West Burton Solar Project

Land Plan Revision ~~A~~B - Change Application Version (Tracked)

PINS reference: EN010132

Document reference: ~~APPCR1~~/WB2.2_ ~~A~~B

Land Plans
Sheet 1 of 10
Revision A

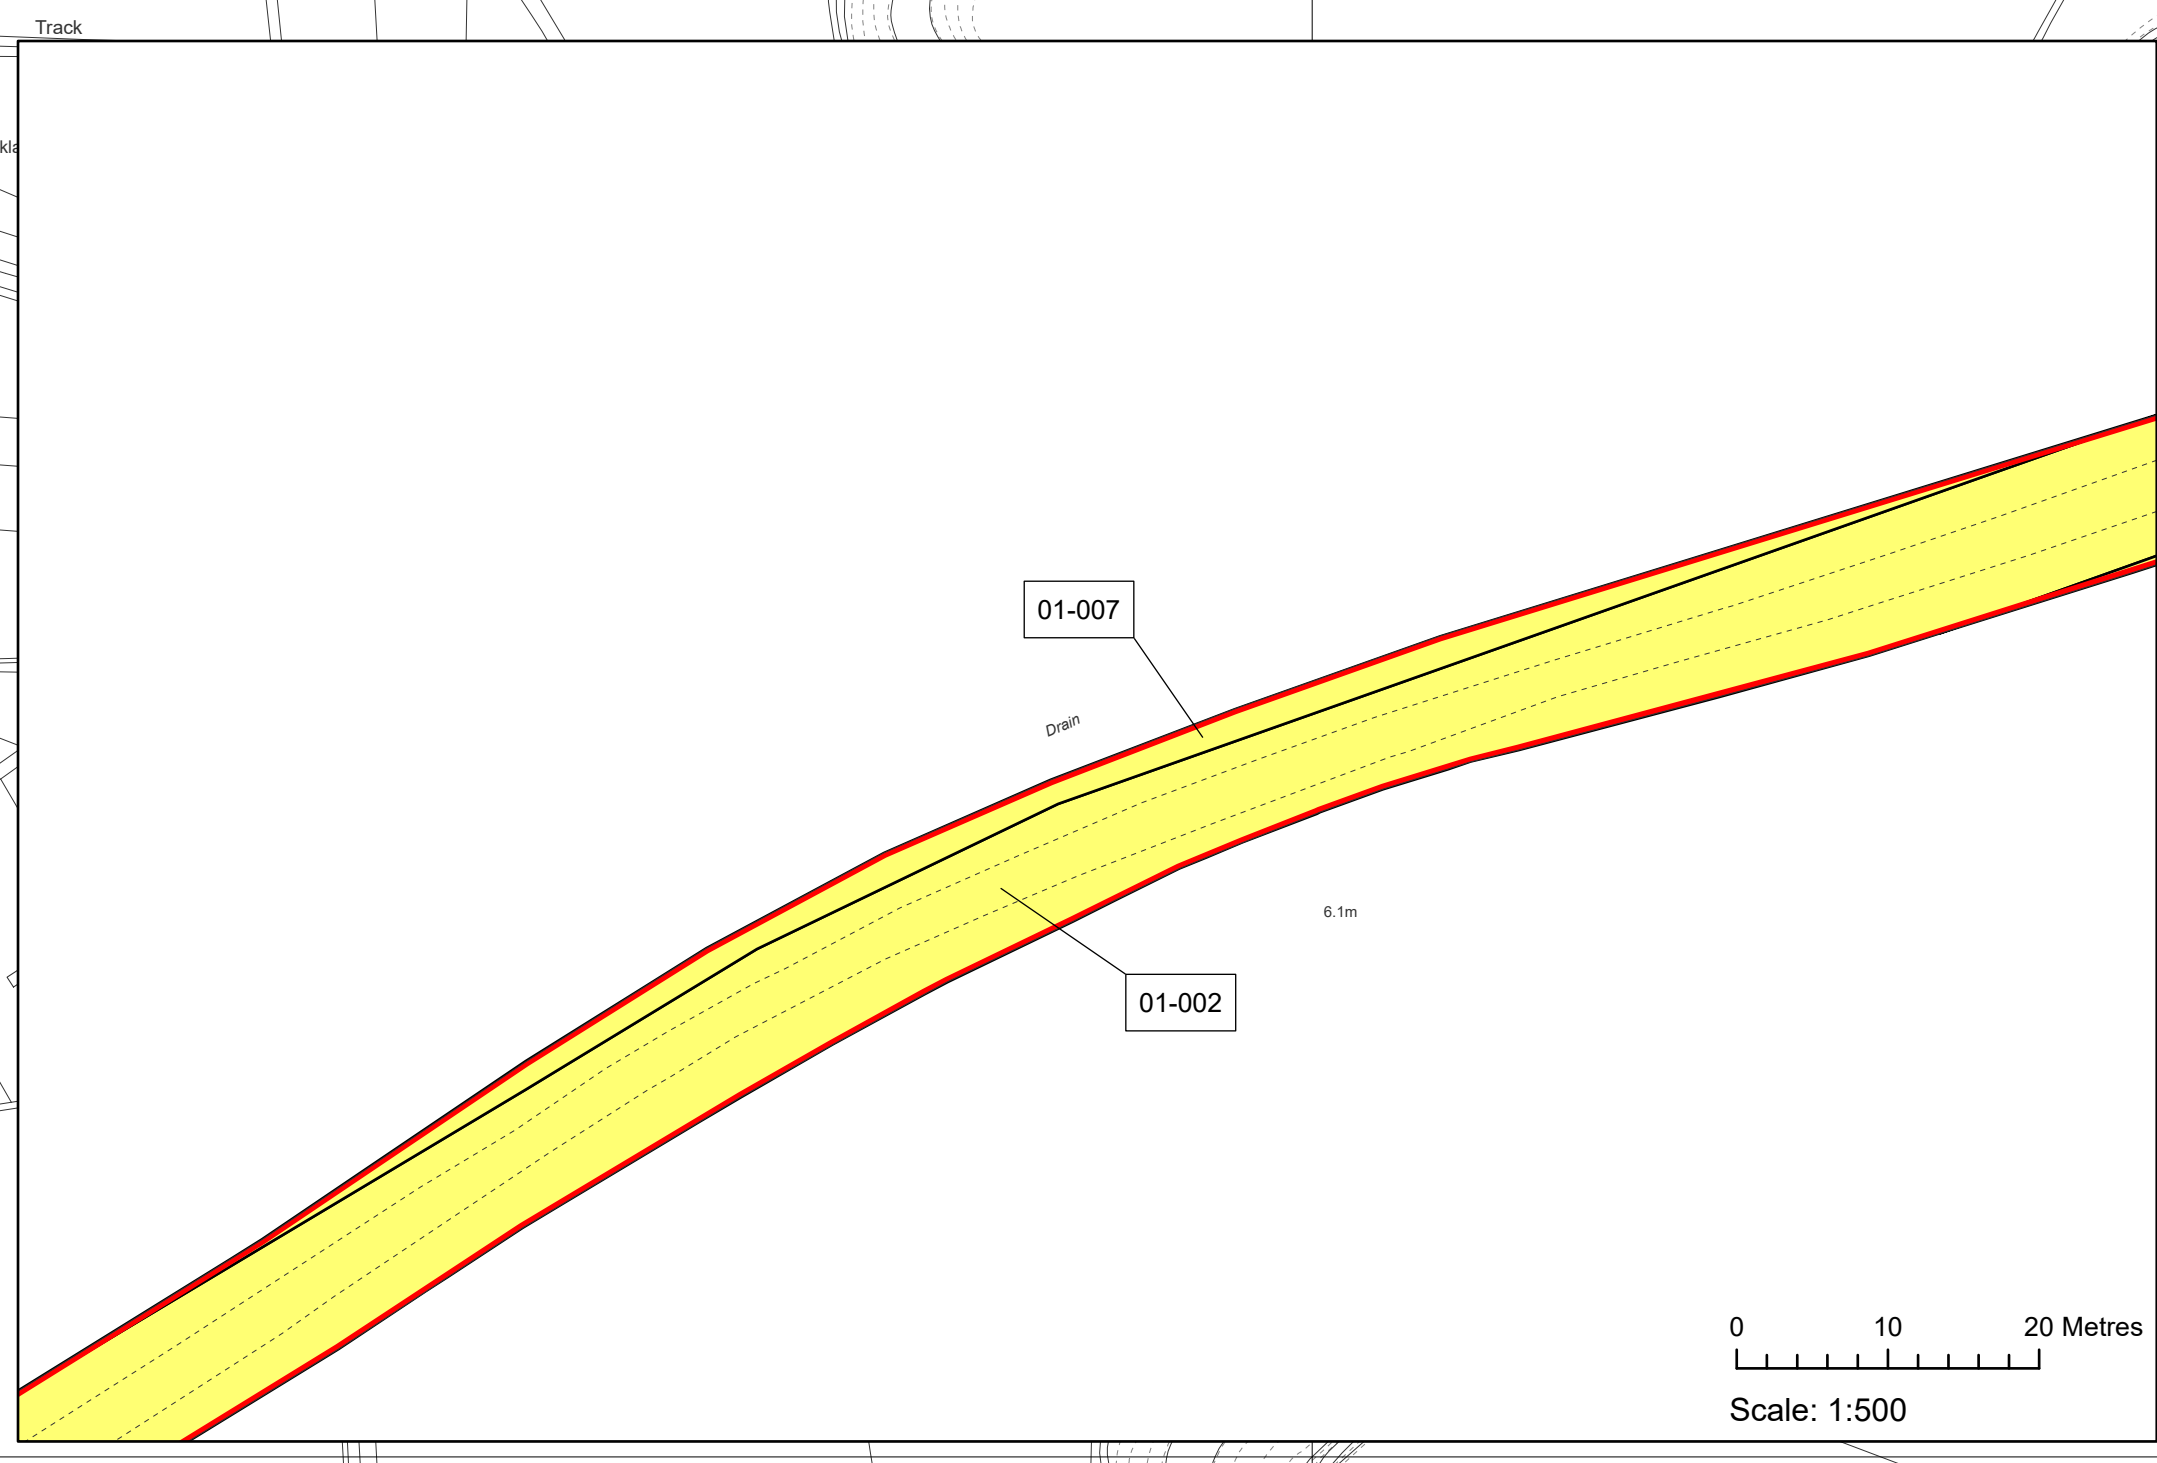
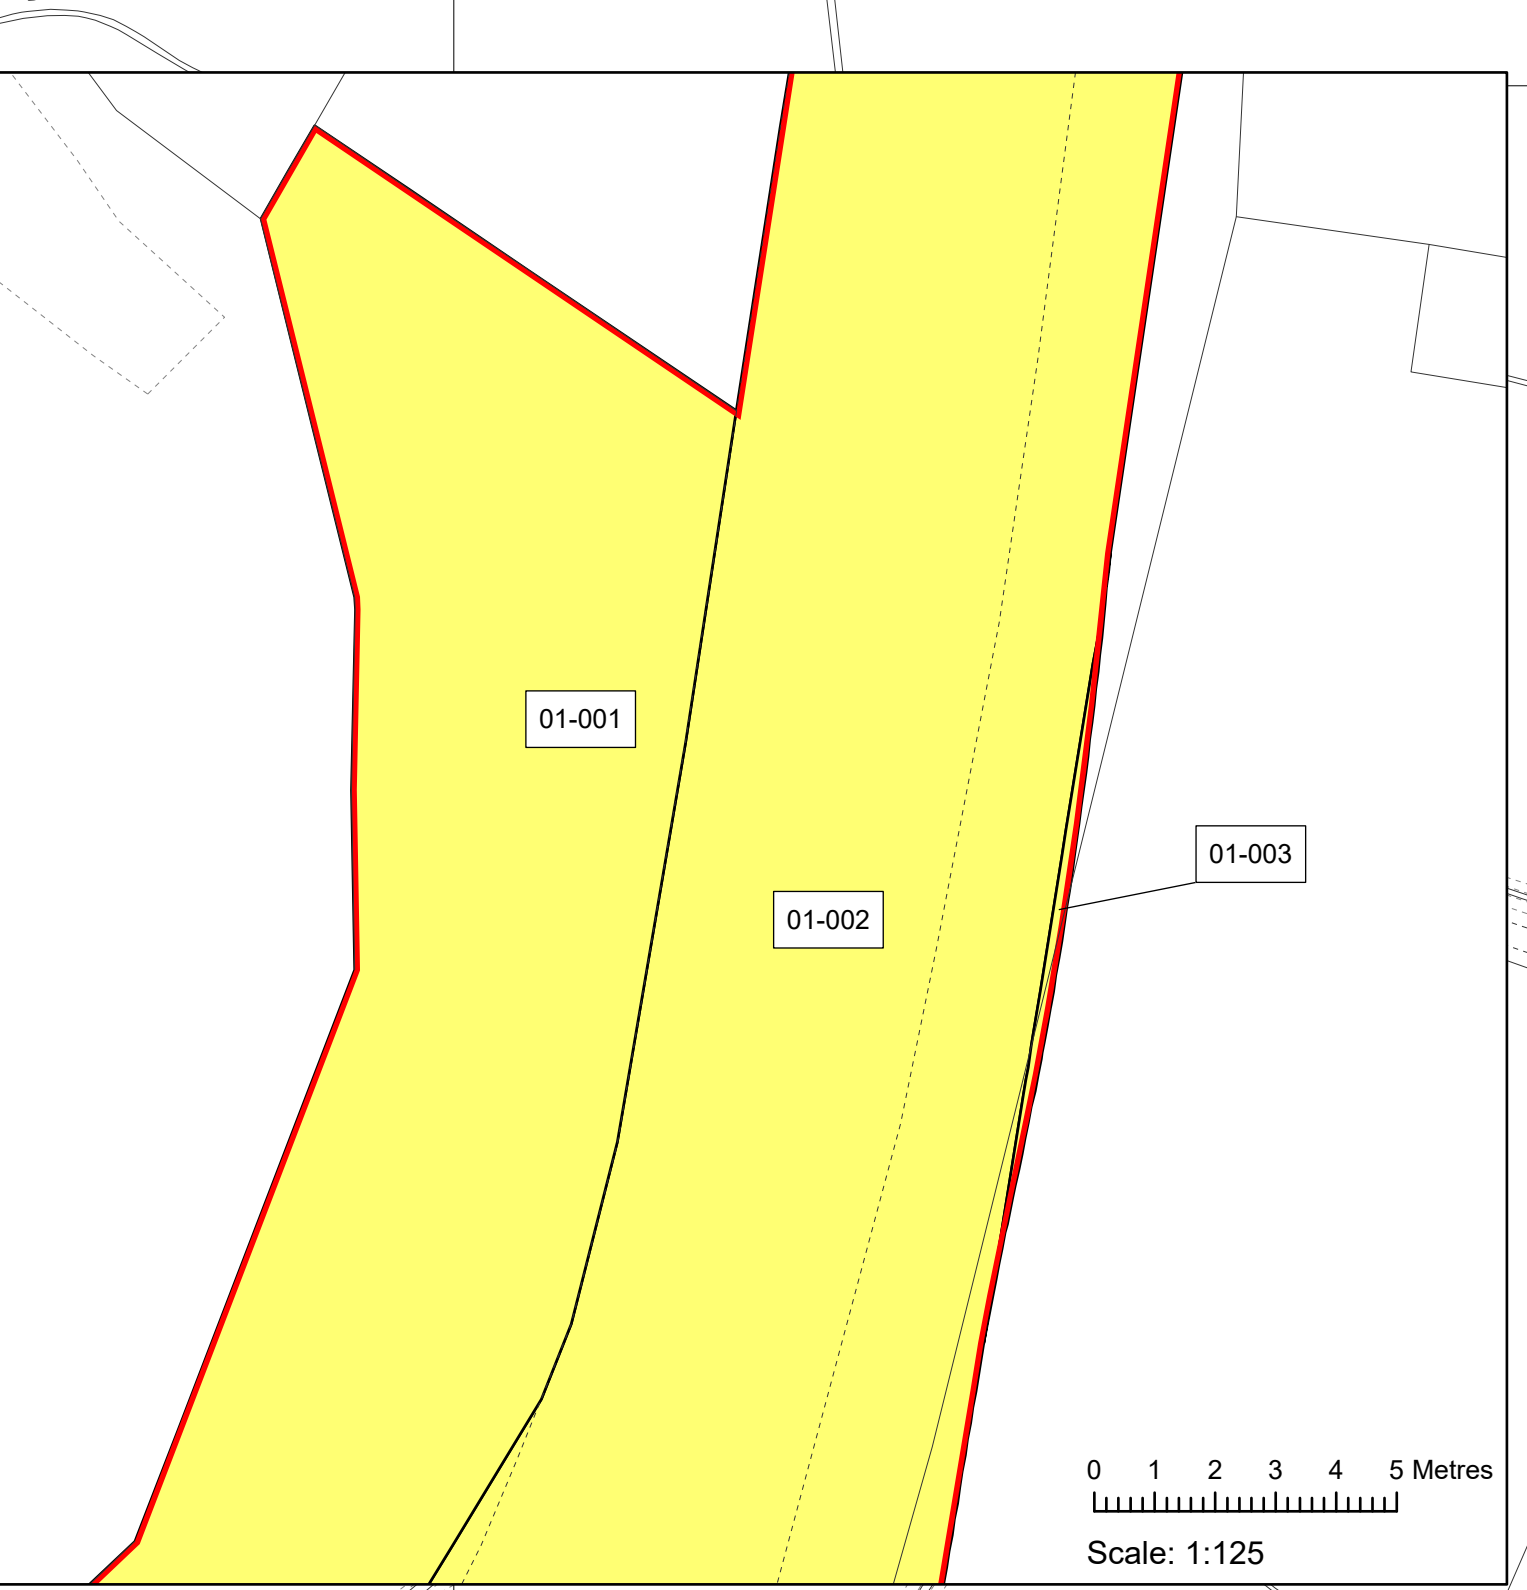
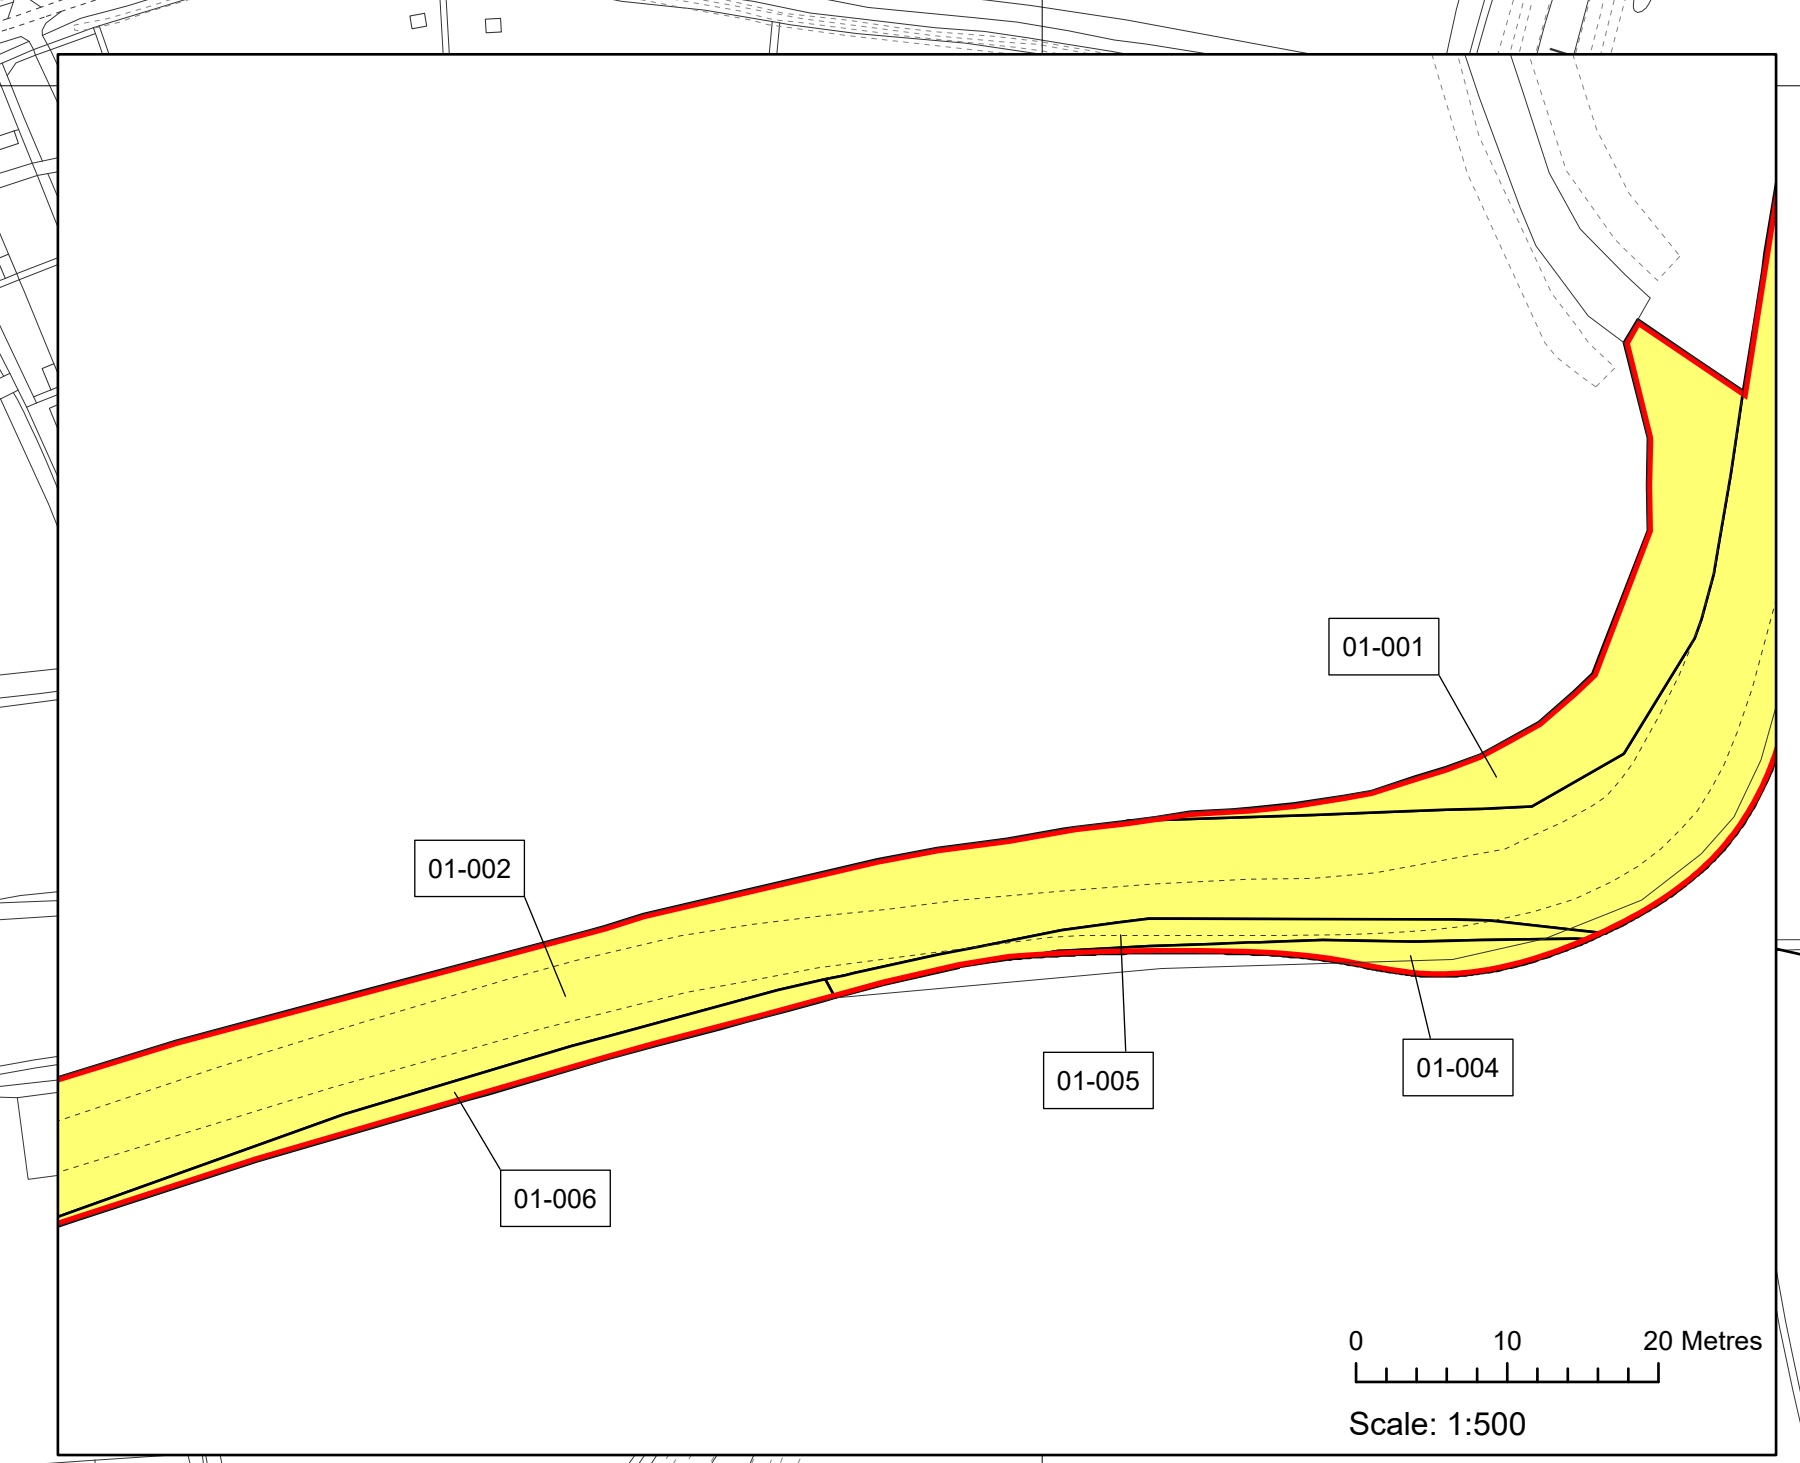
Sheet 1 of 10	5	New plot added	Changes in the Red Line Boundary have created plot 01-002a
Sheet 1 of 10	5	Update to the list of plots in the key on Sheet 1	Updated to reflect addition of new plot 01-002a

Land Plans
 Sheet 5 of 10
 Revision A

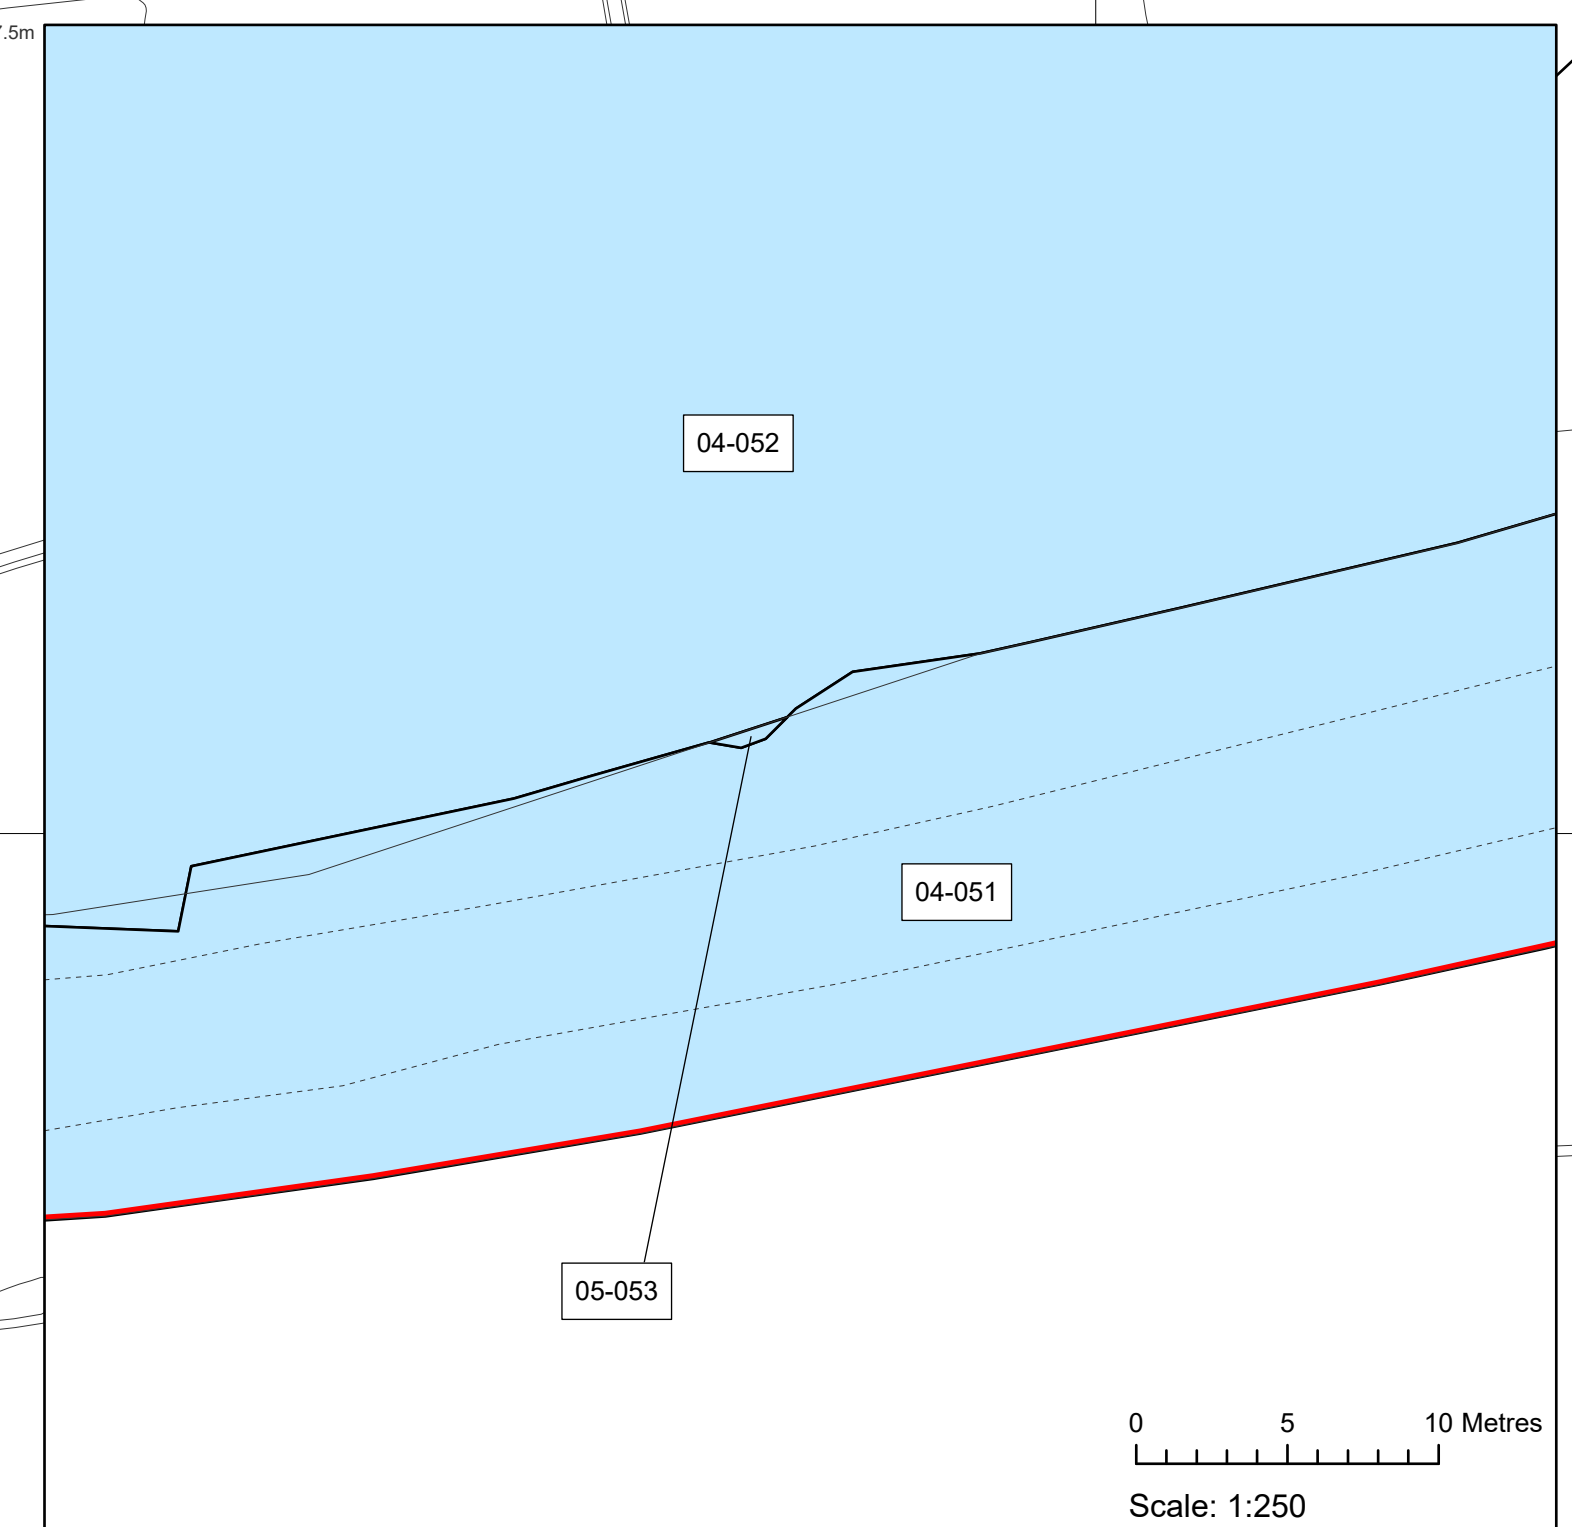
Sheet 5 of 10	9	New plots added	Changes in the Red Line Boundary have created plots 05-052a & 05-054a
Sheet 5 of 10	9	Plot acquisition type changes	Changes to acquisition required for sufficient flexibility for plot 05-054

Sheet 5 of 10	9	Update to the list of plots in the key on Sheet 5	Updated to reflect addition of new plots 05-052a & 05-054a. Updated to reflect change in acquisition of 05-054a
